WELWYN HATFIELD COUNCIL – DEVELOPMENT CONTROL
DELEGATED REPORT

APPLICATION No:	S6/2009/0790/FP
------------------------	------------------------

This application seeks full planning permission for the erection of a single storey side extension and loft conversion to include side dormer, roof light window to front and side and a rear hip to gable conversion.

Drawing Proposed elevations

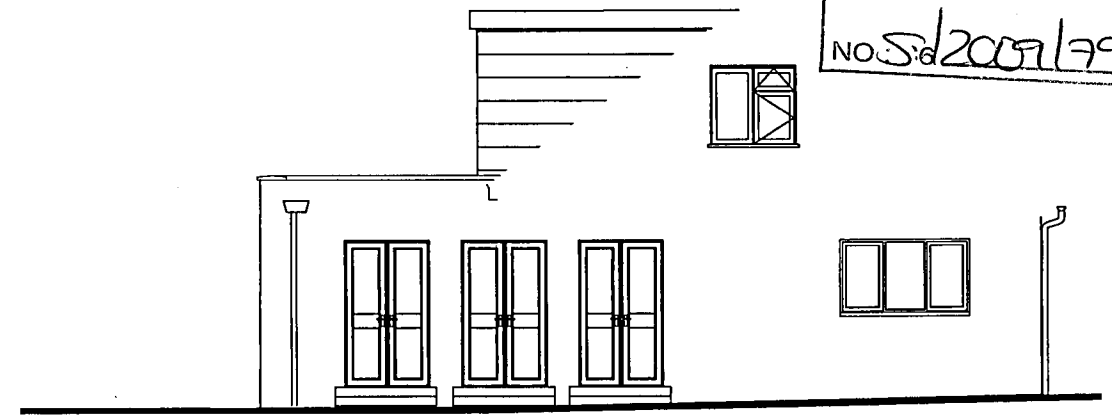
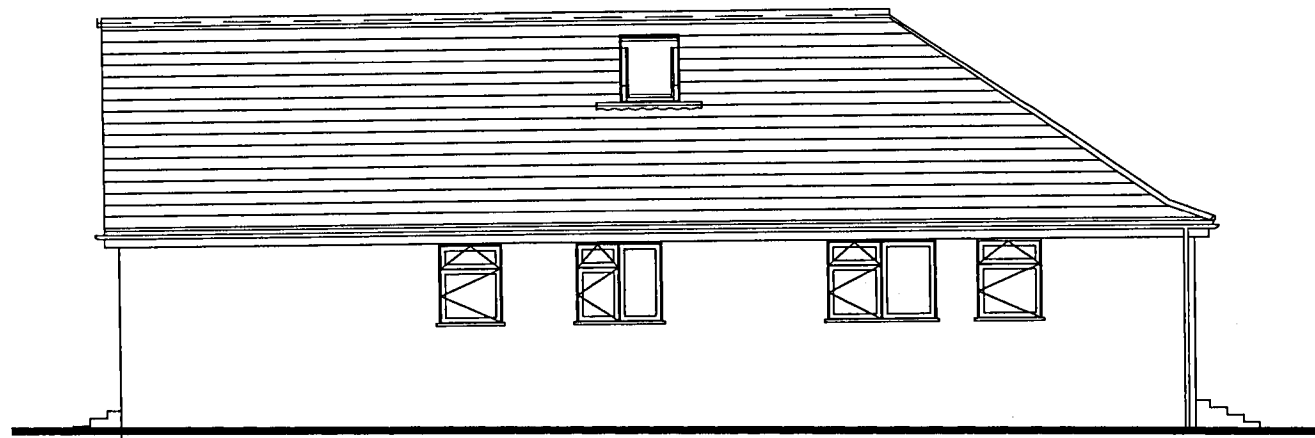
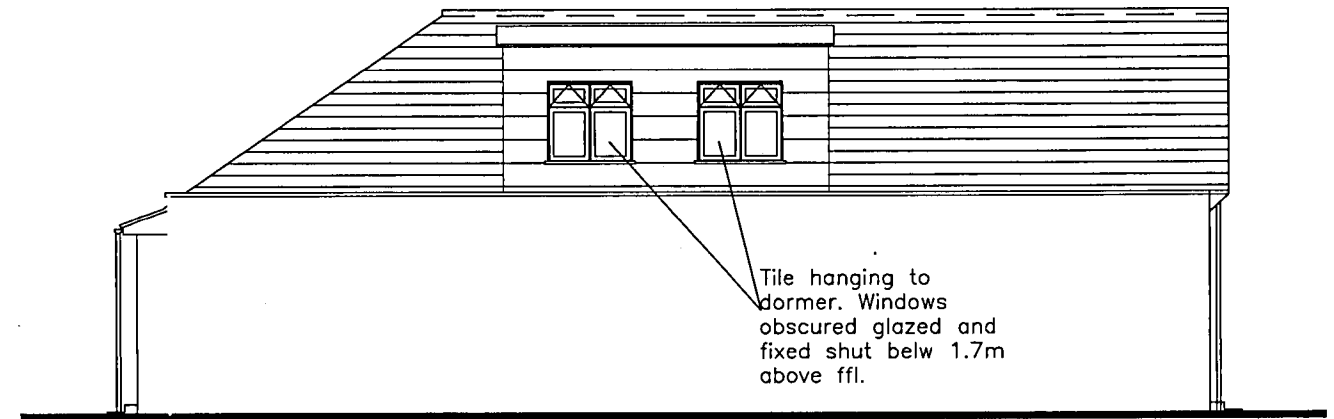
The proposed side dormer, by virtue of its location, scale, bulk and design, would neither complement nor reflect the character and design of the existing dwelling or that of the context of the area. The side dormer would not appear subservient to the roof of the existing dwelling and would create an unbalanced appearance.

The single storey side extension would appear unduly prominent by virtue of the height of the proposed parapet exceeding the eaves height of the main roof by 500mm. The existing bungalow sits comfortably in its setting of similarly designed and well spaced dwellings on the western side of Theobalds Road. The side extension would disrupt the prevailing pattern of development and the generally well ordered street scene. A distinct lack of separation between the proposed side extension and No.34 Theobalds Road would give the extended bungalow a cramped and ungainly appearance. The proposals therefore fails to comply with PPS1 Delivering Sustainable Development, Policy SS1 and ENV7 of the East of England Plan 2008, Policy D1 and D2 of the Welwyn Hatfield District Plan 2005 and the accompanying Supplementary Design Guidance (Statement of Council Policy).

The lack of separation and the height of the proposed side extension would have a detrimental impact on light amenity to the windows on the south elevation of No.34 Theobalds Road serving a kitchen and dining room. The resulting loss of daylight would spoil the occupiers reasonable enjoyment of their property, contrary to the good design principles required by PPS1 Delivering Sustainable Development, Policy SS1 and ENV7 of the East of England Plan 2008, Policy D1 and D2 of the Welwyn Hatfield District Plan 2005 and the accompanying Supplementary Design Guidance (Statement of Council Policy).

1. The proposed side dormer, by virtue of its location, scale, bulk and design, would neither complement nor reflect the character and design of the existing dwelling or that of the context of the area. The side dormer would not appear subservient to the roof of the existing dwelling and would create an unbalanced appearance. The proposed development therefore fails to comply with PPS1 Delivering Sustainable Development, Policy SS1 and ENV7 of the East of England Plan 2008, Policy D1 and D2 of the Welwyn Hatfield District Plan 2005 and the accompanying Supplementary Design Guidance (Statement of Council Policy).

2. The single storey side extension would appear unduly prominent by virtue of the height of the proposed parapet exceeding the eaves height of the main roof by approximately 500mm. The proposed side extension would disrupt the prevailing pattern of development and the generally well ordered street scene. A distinct lack of separation between the proposed side extension and No.34 Theobalds Road would give the extended bungalow a cramped and ungainly appearance. The proposed development therefore fails to comply with PPS1 Delivering Sustainable Development, Policy SS1 and ENV7 of the East of England Plan 2008, Policy D1 and D2 of the Welwyn Hatfield District Plan

3. The lack of separation and the height of the proposed extension would have a detrimental impact on light amenity to the windows on the south elevation of No.34 Theobalds Road serving a kitchen and dining room. The resulting loss of daylight would spoil the occupiers reasonable enjoyment of their property, contrary to PPS1 Delivering Sustainable Development, Policy SS1 and ENV7 of the East of England Plan 2008, Policy D1 and D2 of the Welwyn Hatfield District Plan 2005 and the accompanying Supplementary Design Guidance (Statement of Council Policy).

Drawing Proposed Plans

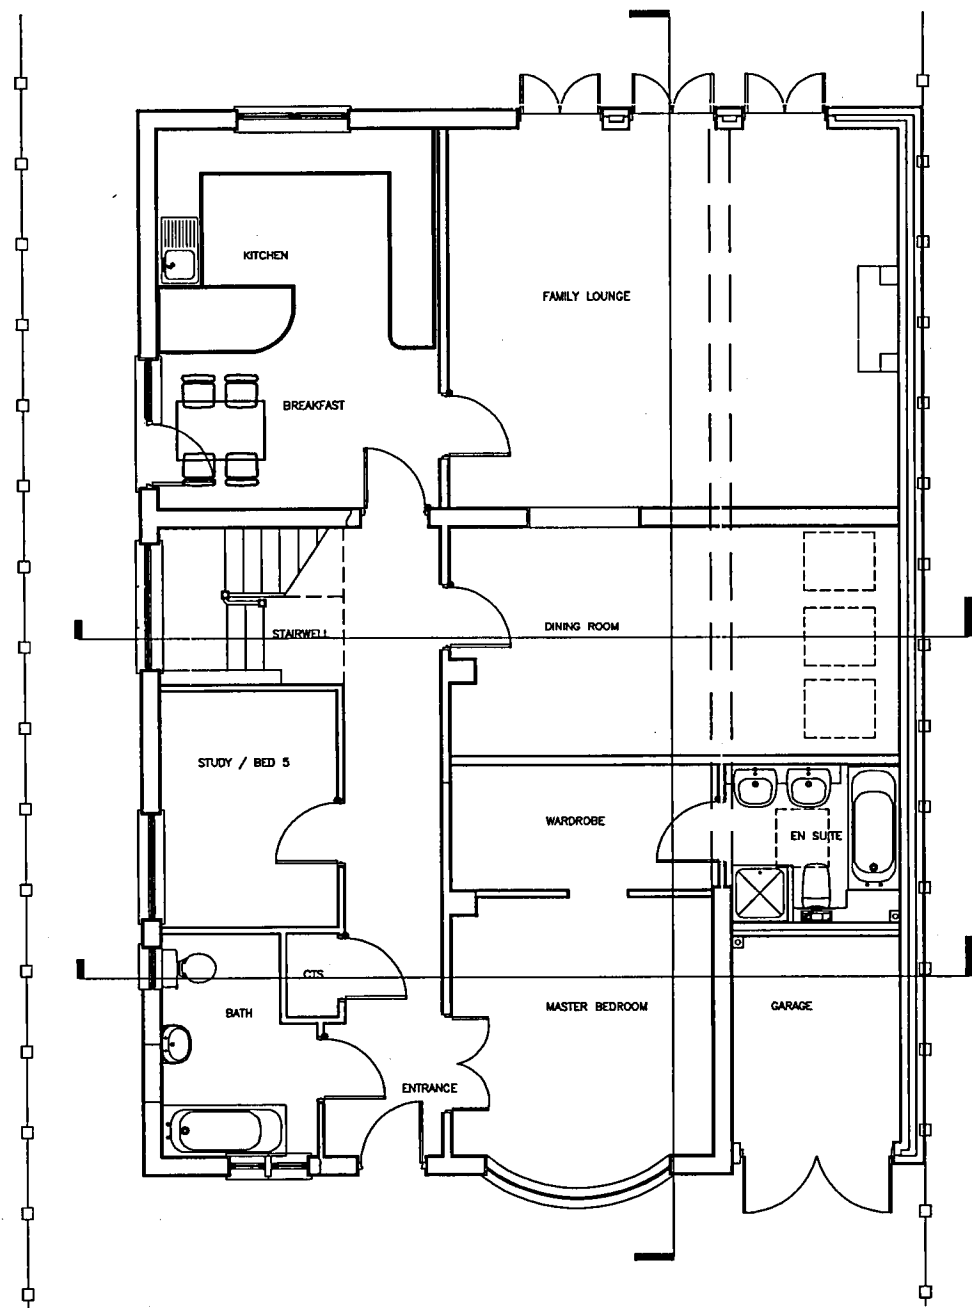
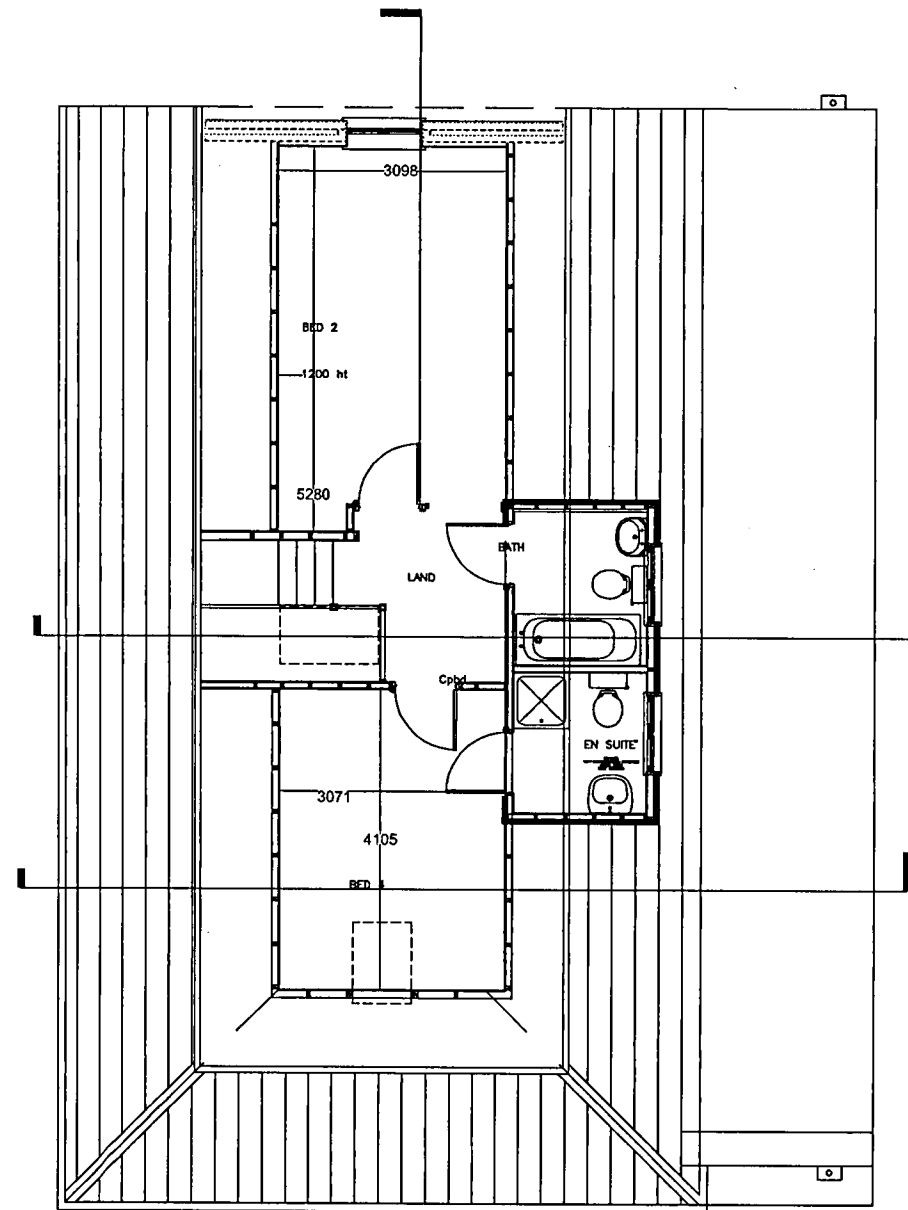
One letter of representation was received objecting to the proposals on the grounds that the extension would result in loss of privacy and light amenity to No.34 Theobalds Road. The application dwelling features two existing windows at ground floor level within the north facing flank elevation. No windows are proposed within the side extension resulting in an improvement

over the current situation in terms of privacy. The proposed dormer would feature two windows serving a bathroom and an en-suite. Should an appeal or similar planning application be granted in the future it would be reasonable to attach a planning condition requiring these windows to be obscure glazed and fixed below a height of 1.8m. Accordingly, there would be no adverse impact in terms of private amenity as a result of the proposed development.
